PROJECT: Meriden School
RE: SDRP Lite – 21.08.2018

Centre for Music and Drama – Senior Campus

Drawing Title
FLOOR PLAN - LEVEL 0
(GROUND)

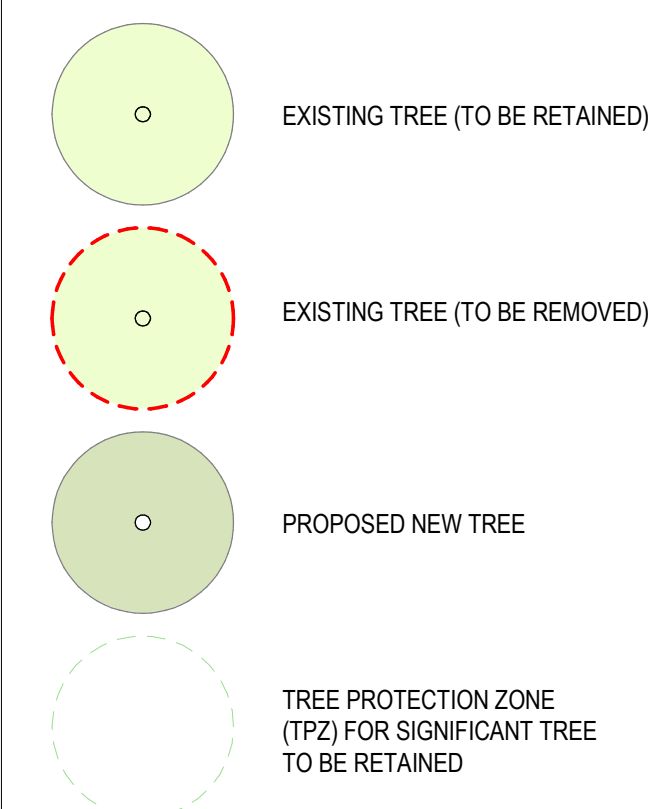
The levels and stairs inside the building may make it difficult to navigate. The panel recommends further resolution of level changes to ensure the number of stairs are reduced and equitable access is provided.

While the panel accepts that the uses of the building can be accommodated on the lower ground, daylight analysis is required to validate adequate illumination to these areas for morning, midday and afternoon. The panel would also like to see further evidence that these spaces receive natural light through the skylights and double screens of the building.

ELEVATION - NORTH / EAST

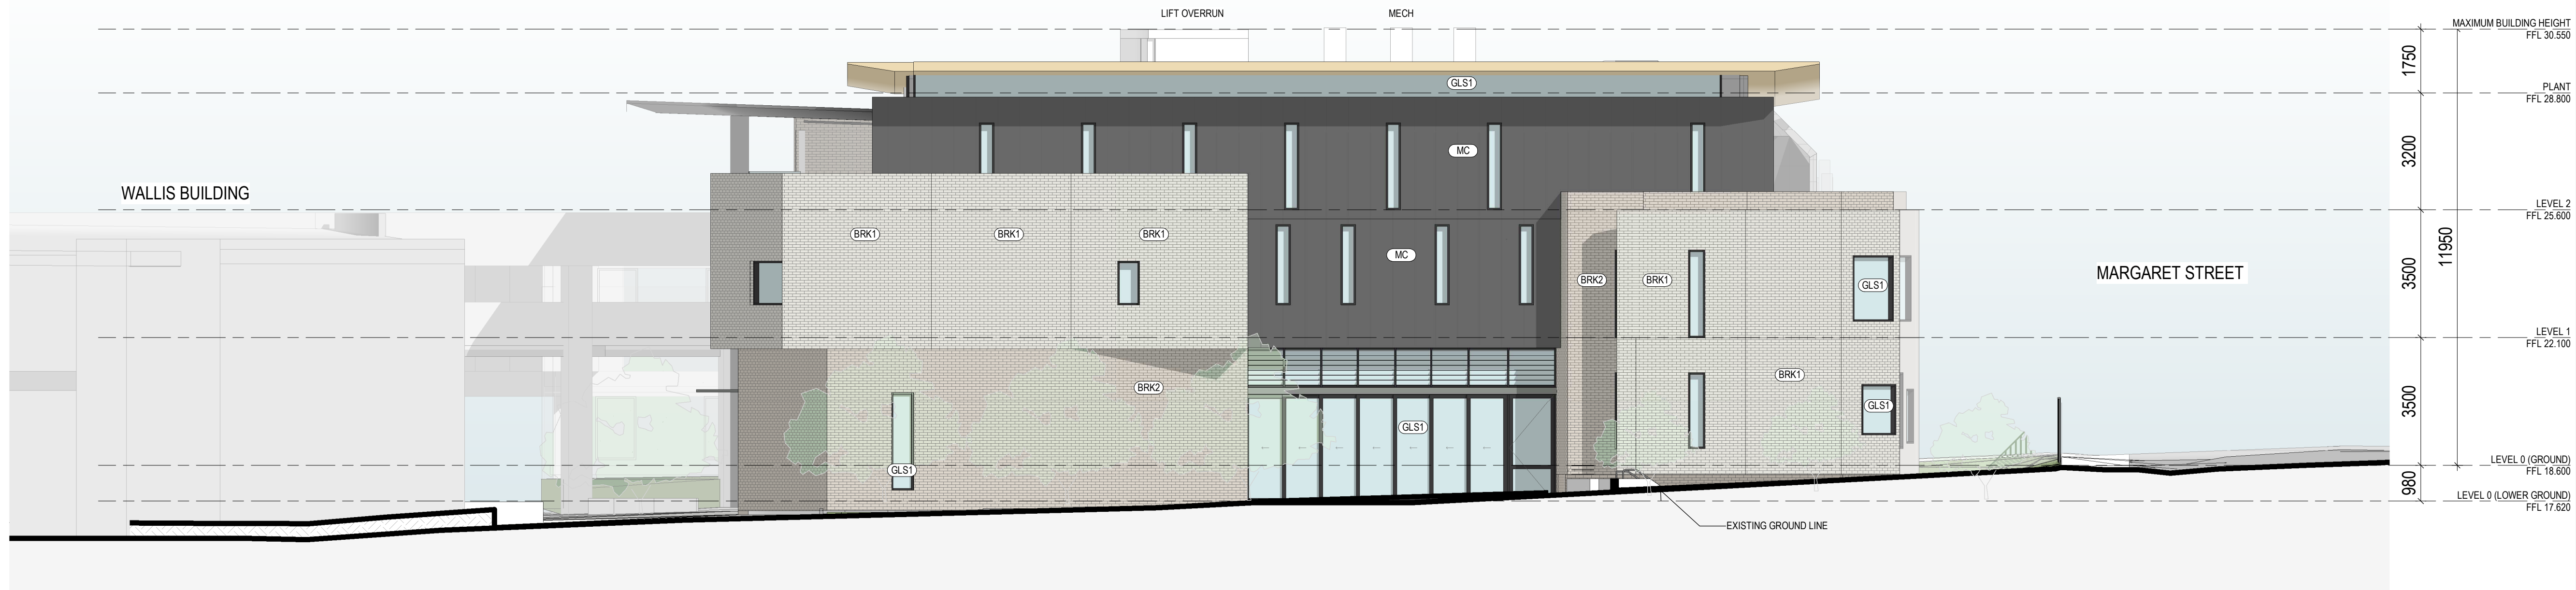
The panel supports the staggered approach to the eastern façade as a transition from the Wallis Auditorium. The panel also supports the entry slot which provides the transition between the Hope Turner Building and the proposal. The panel requires detailed elevations and photomontages to provide overall support to the built form and its relationship to existing buildings and the streetscape. Detailed information about the façade strategies, materials palette, finishes and colours should be provided at the next SDRP.

ELEVATION - SOUTH / WEST

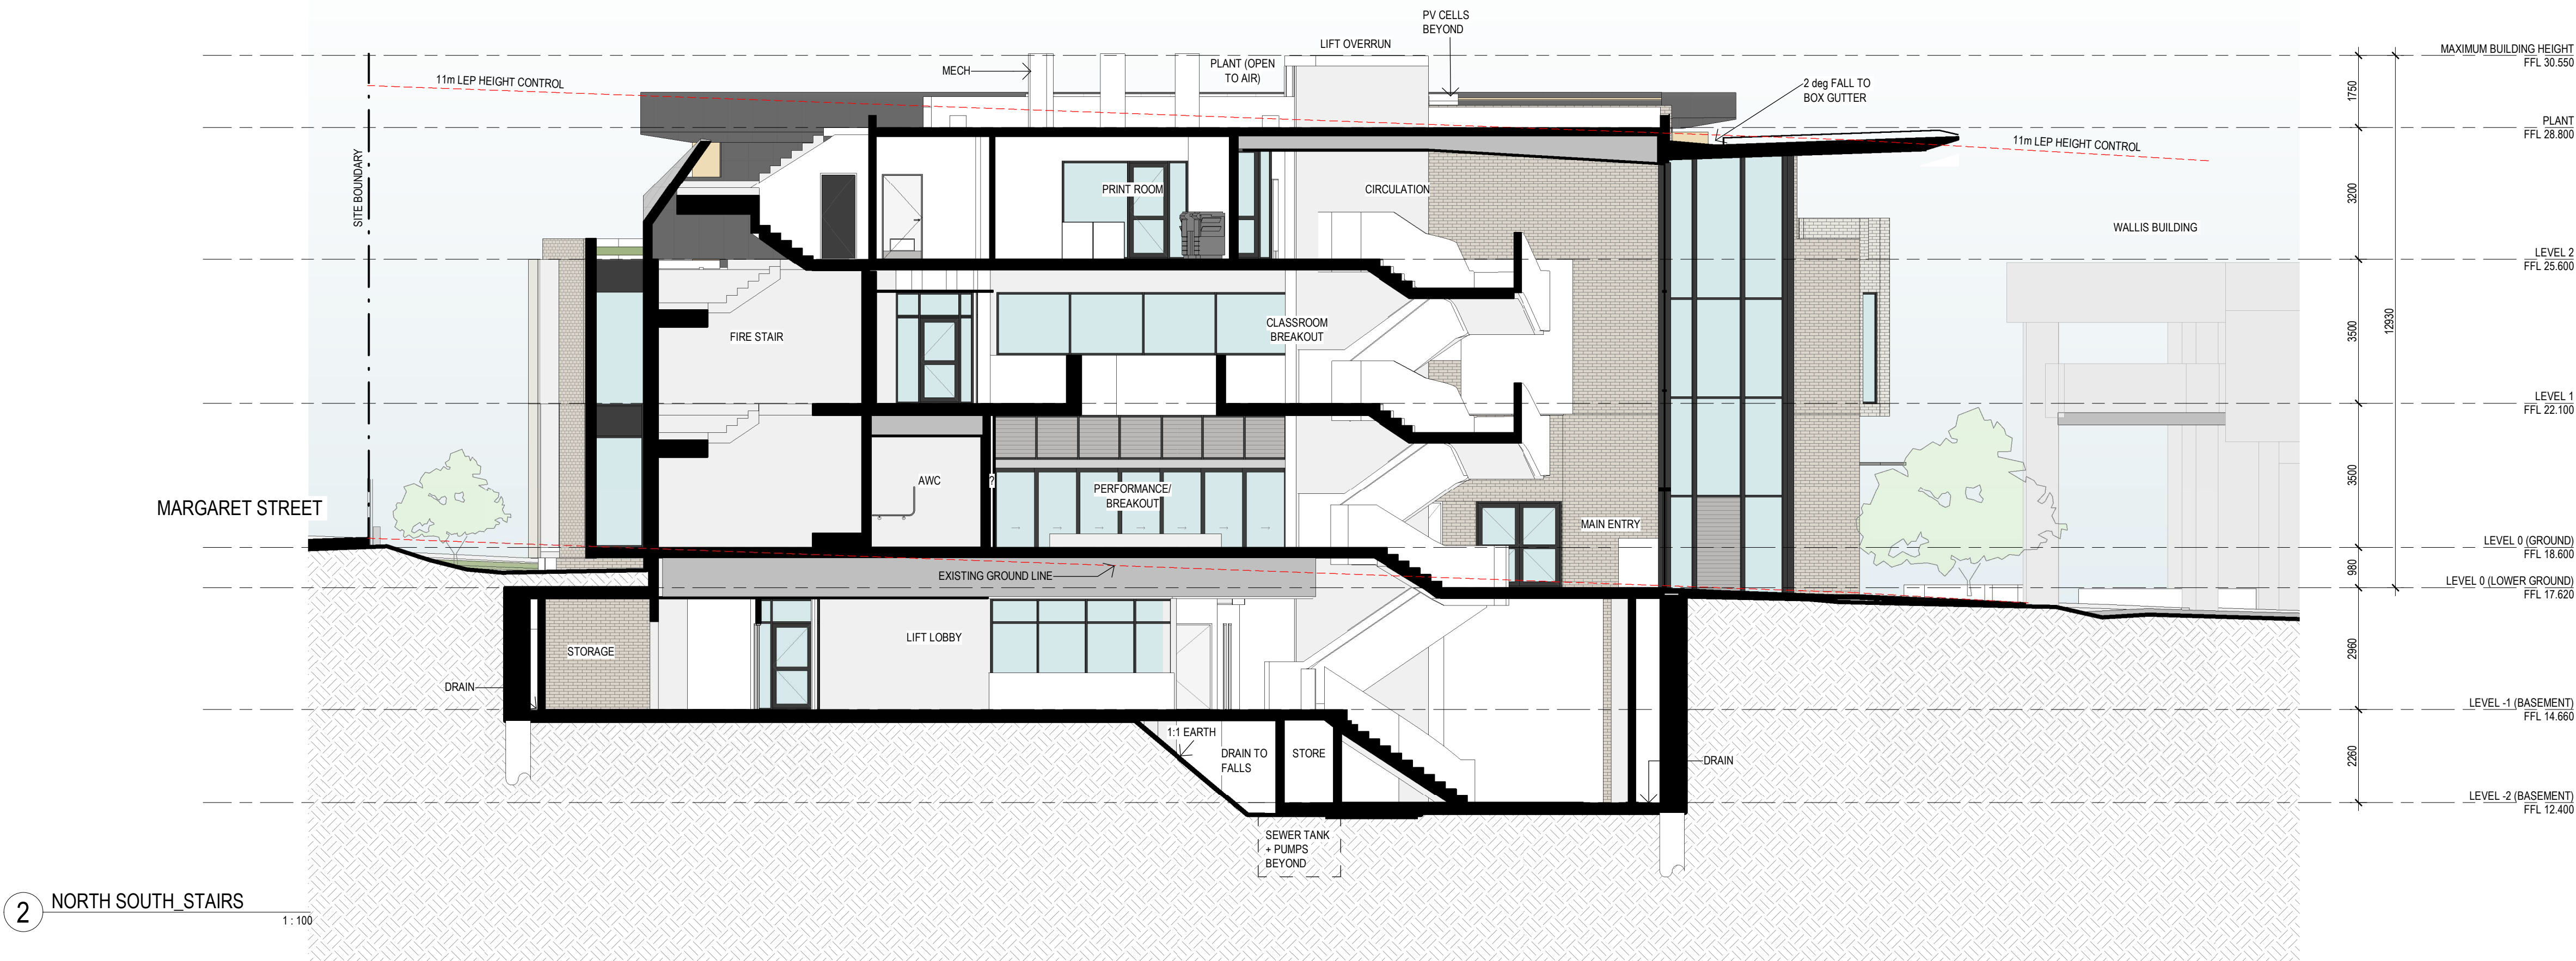
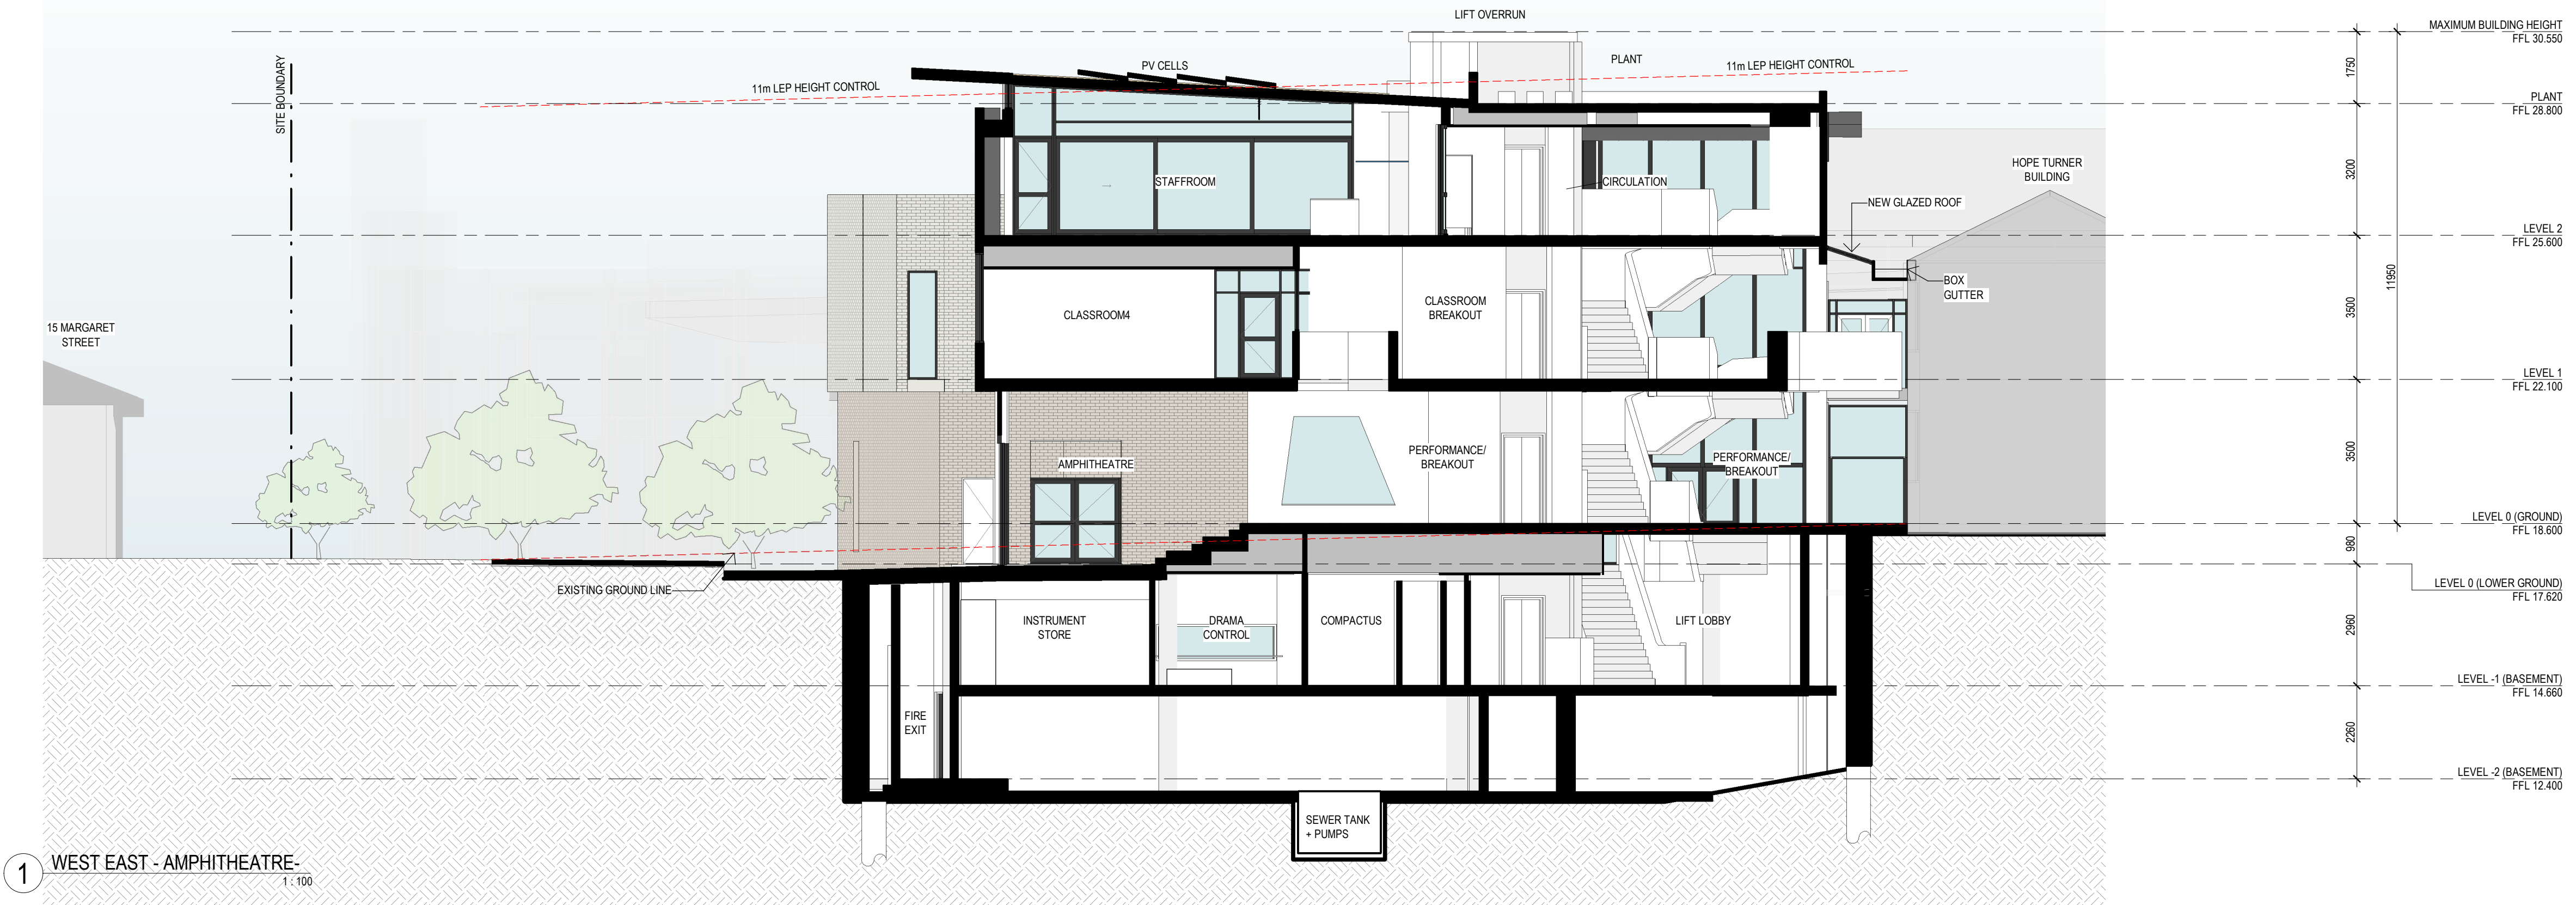
The stairs and ramps facing Margaret Street should also be simplified to provide an intuitive entrance sequence.

WALL SECTION - AMPHITHEATRE - 1-20

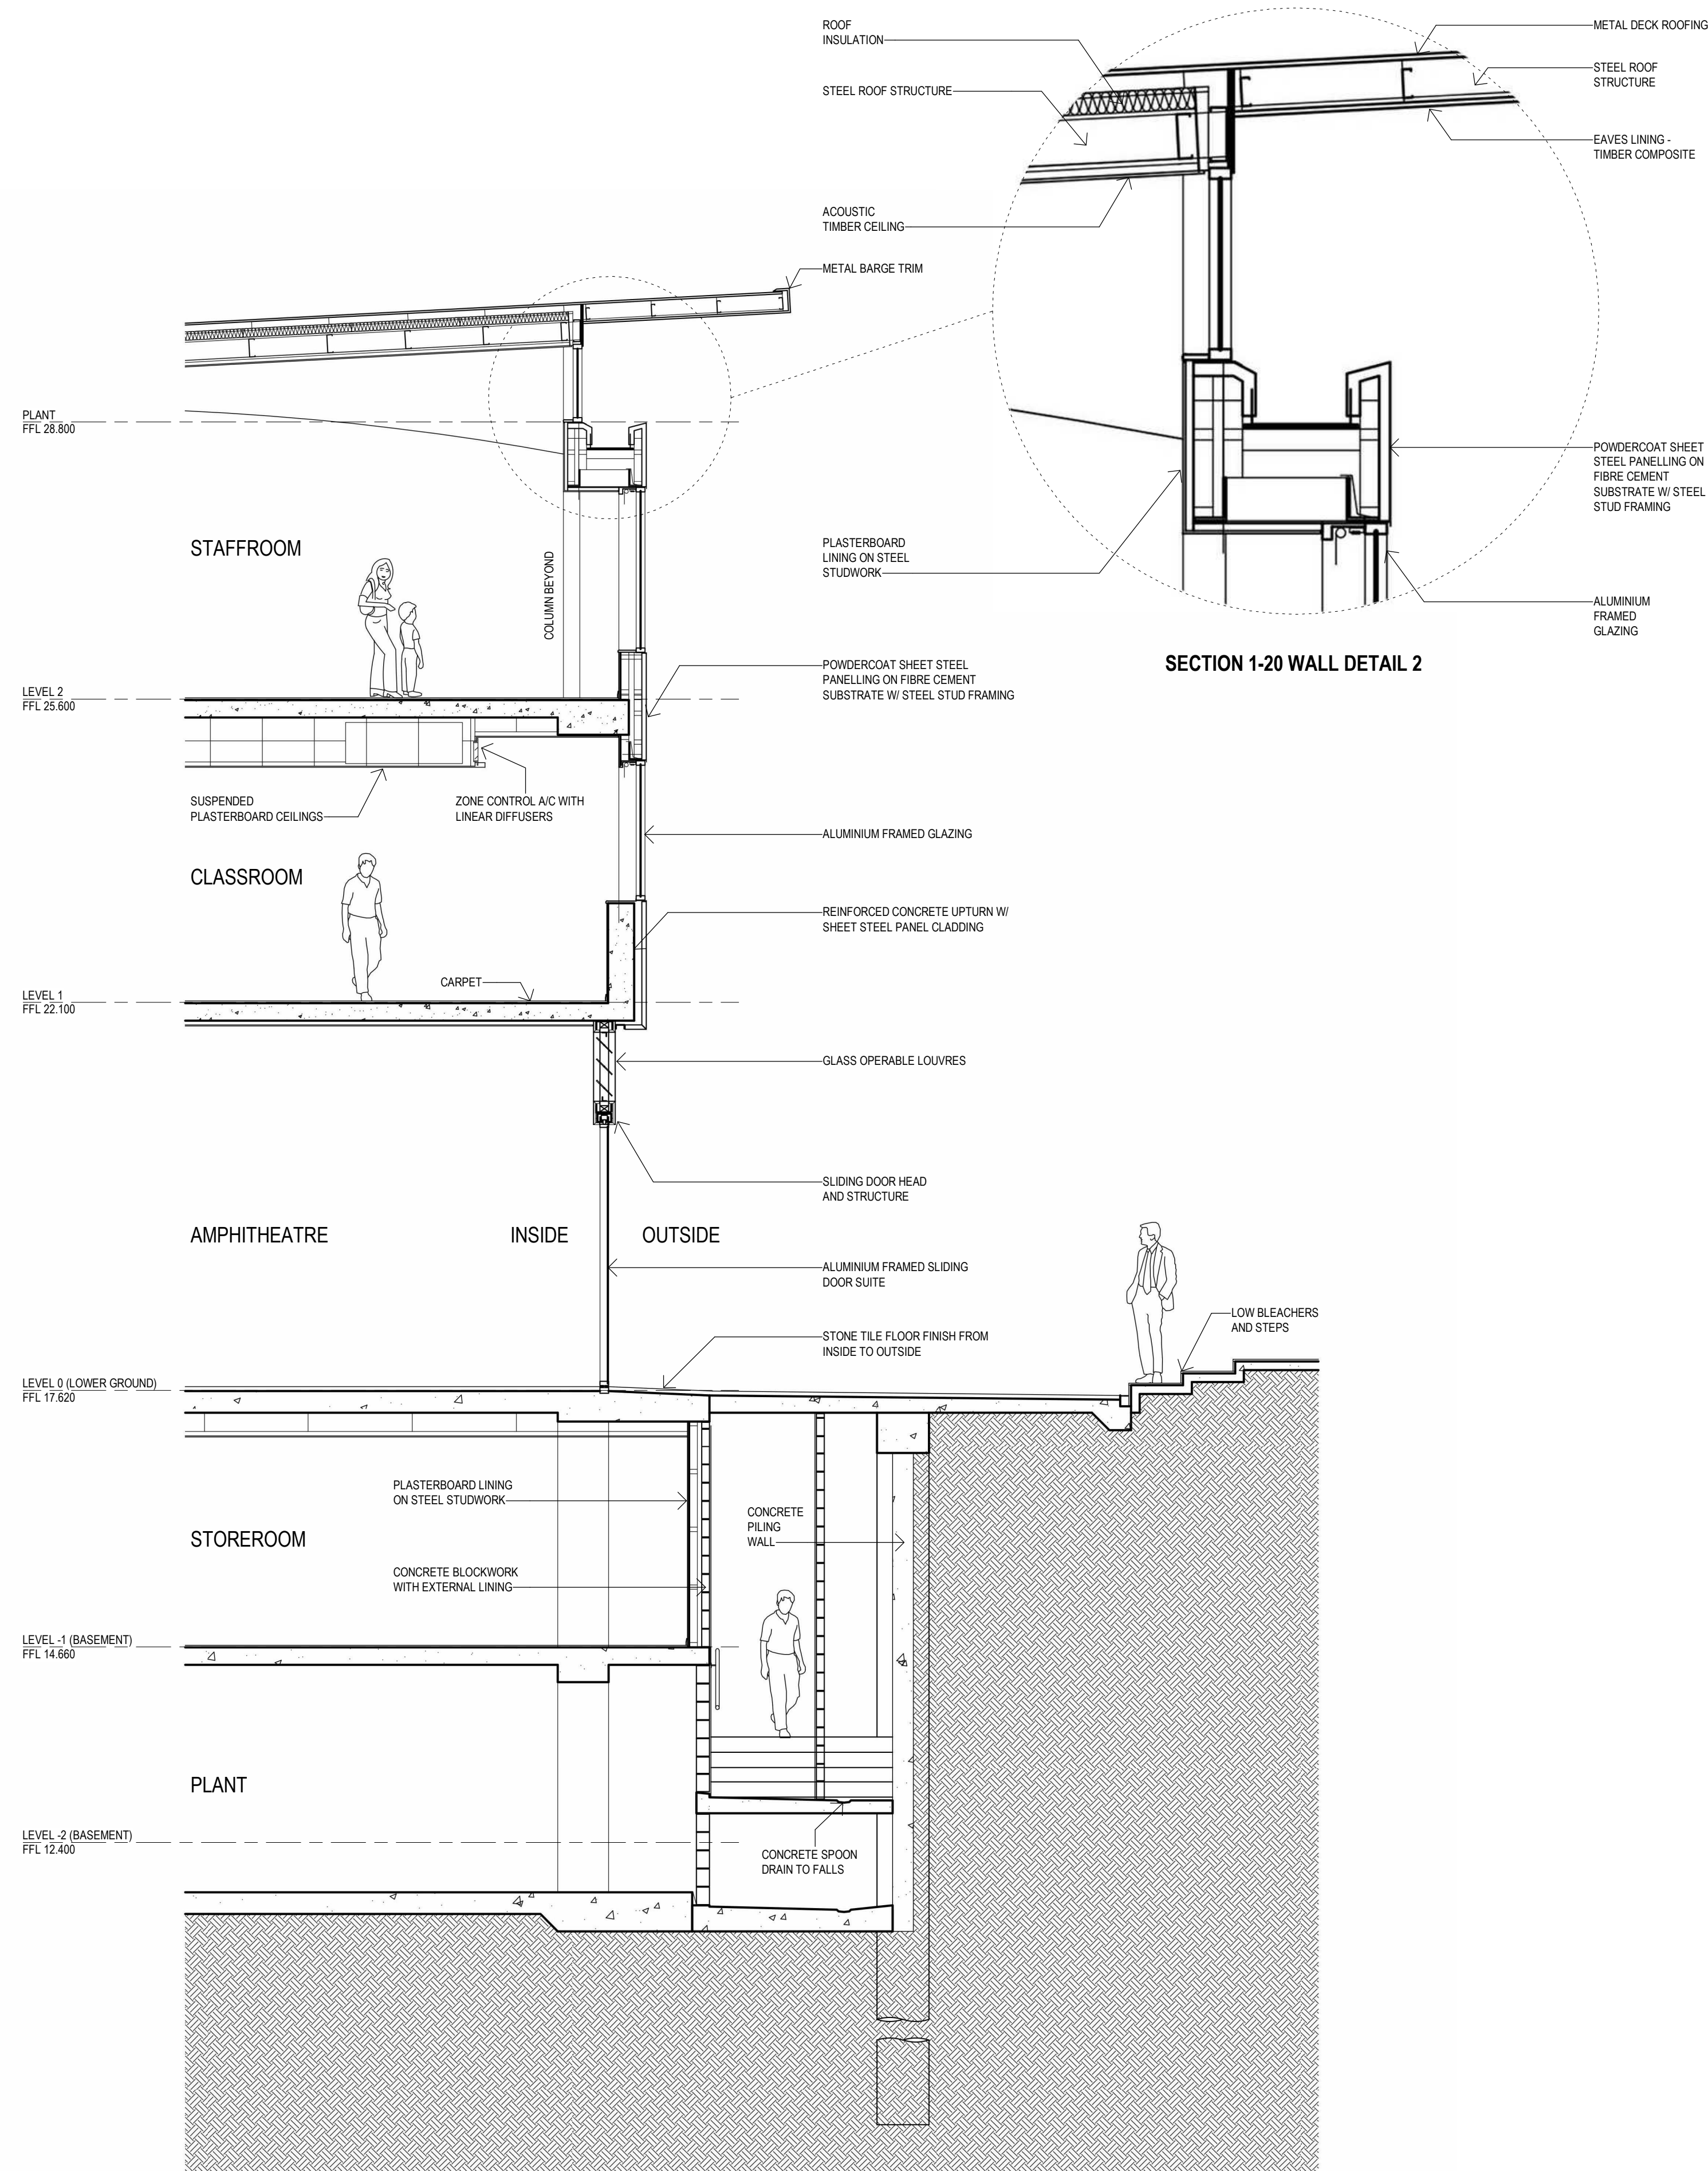
The amphitheatre is a great space for gathering, informal education and open days. It is welcoming and however it looks like an entrance when the entrance should be as described above. The project team is encouraged to articulate landscape elements in the amphitheatre to ensure this space is not mistaken for the main entrance.
